From: Gary Cowan [REDACTED]
Sent: 29 January 2016 20:51
To: M4 Junction 3-12 Smart Motorway
Subject: Re: Environmental issues on M4 additional comment my ref 10031529

From Cllr Gary Cowan 10031529

Project	SMART MOTORWAYS PROGRAMME
	M4 JUNCTIONS 3-12
Drawing title	ENVIRONMENTAL MASTERPLAN
	REGULATION 4(2)(e)
	SHEET 14 OF 61
	LOWER EARLEY

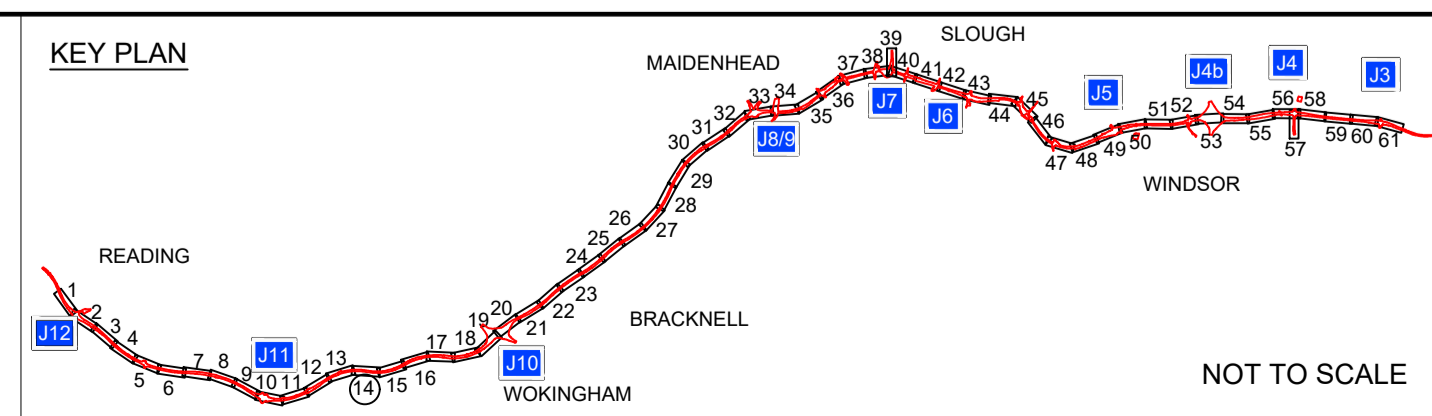
People living in all affected properties should be availed of the same opportunity for noise mitigation. Their human rights should dictate this consideration. Individuals living in properties on the south side, and close to the motorway, have been affected by the nuisance of road noise from the M4 in just the same way as those living to the north, for example in Lower Earley.

In fact, their claim may be said to be greater because the properties in Lower Earley were built many years after the motorway was completed. An individual living to the south of the M4 is just as entitled as one living to the north to whatever relief may be available from the constant road traffic noise from the motorway.
